CMCC 240807 PI/MONA
Response 2

Planning Inspectorate Examination EN010137: Mona Offshore Wind

Cefn Meiriadog Community Council
MNOW-SP036

Response of the Community Council to issues raised at Issue-Specific Hearing 2

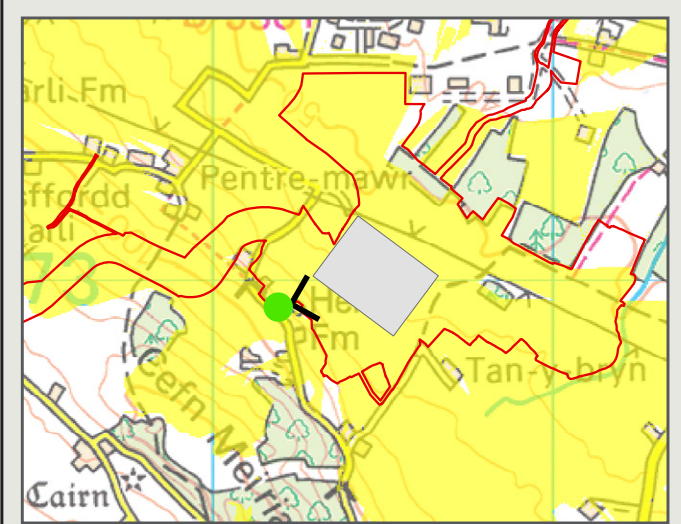
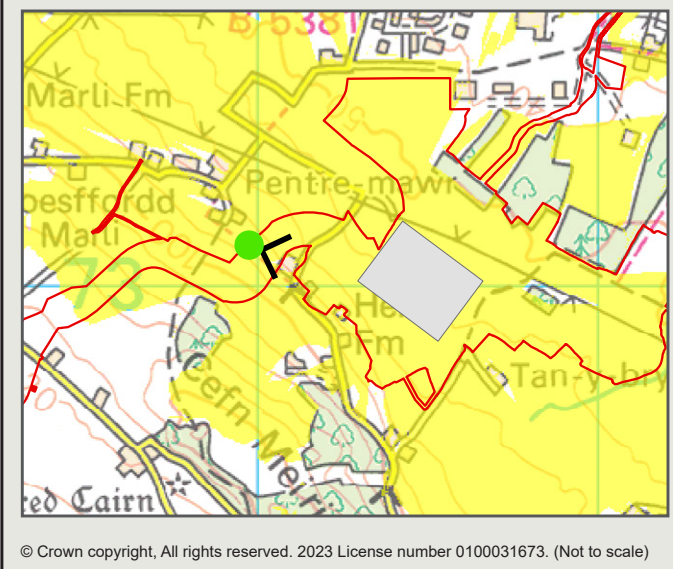
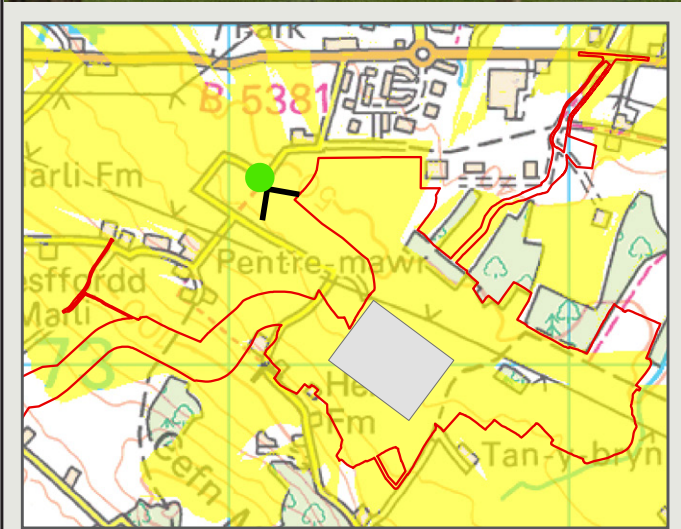
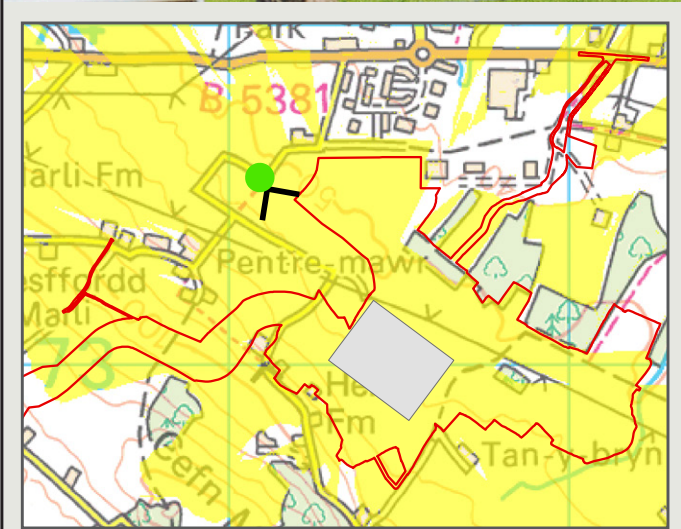
4b. The Applicant's stated reason for omitting the masts from the visualisations and the assessments - that there is an electricity pylon nearby which is taller than the proposed masts - is not only unconvincing, but raises further questions about the reliability of the Applicant's whole approach. This is epitomised by discussion around PDA034, Figure 1 of Landscape Visualisations (reproduced below). Therefore this visualisation is discussed as representative of the flaws underlying the Applicant's assessments of visual impact.

4c. National Grid has already stated in its published documents and its consultations that the pylon shown in the foreground will be removed following the extension to its 'Bodelwyddan Substation' (actually in Cefn Meiriadog) being carried out precisely to be able to accommodate the additional power generated by Mona and Awel y Môr. The line it carries to the NG substation will be replaced by two lines, neither coinciding with the position of the pylon shown. The Applicant acknowledges being in regular contact with NG (and other relevant parties), therefore it is puzzling in the extreme that this view has been chosen for a critical visualisation.

4d. Critical because the Applicant stated that the "Minor to moderate adverse significance" found to be the visual impact associated with this viewpoint was for the most part due to the "existing infrastructure", i.e. the pylon and the (largely obscured) ground station to its right. Not only has NG stated that the pylon will be removed, it has said also that the ground station will be decommissioned and the site levelled.

4e. The choice to compose and present a visualisation in which the proposed substation is seen through the legs of a pylon (albeit one that will no longer be there) is highly questionable since it is a fundamental of the laws of perspective that objects depicted in this manner will cause the object in the background to be perceived as smaller than they would be if the foreground object were not present, and smaller than they would be perceived in real life. Viewpoints a few metres either side of the one chosen would not have had this effect and its deliberate choice must be questioned.

4f. Another indication of the flawed nature of the Applicant's LVIA was the Applicant's representative's assertion that the road partially seen in the bottom right of the visualisation is not a right of way. This is simply erroneous, as will be confirmed by Denbighshire County Council who maintain the road as the lesser of two routes linking Groesfordd Marli on the northern side of Cefn Meiriadog with Cefn Mairwen on the southern side, and serving approximately 12-15 dwellings. It also forms part of a popular circular route used by walkers, cyclists and riders, and it is frankly misleading to describe it as "not a right of way". It has even on (admittedly rare) occasions been used as a diversionary route during severe blockages on the A55.

4g. CMCC agrees with Mr Martyn Hussey who has pointed out that the 'before and after' LVIA visualisations are not consistent in the way they show seasonal variation, and they do this in a way that presents the project in the best possible light.
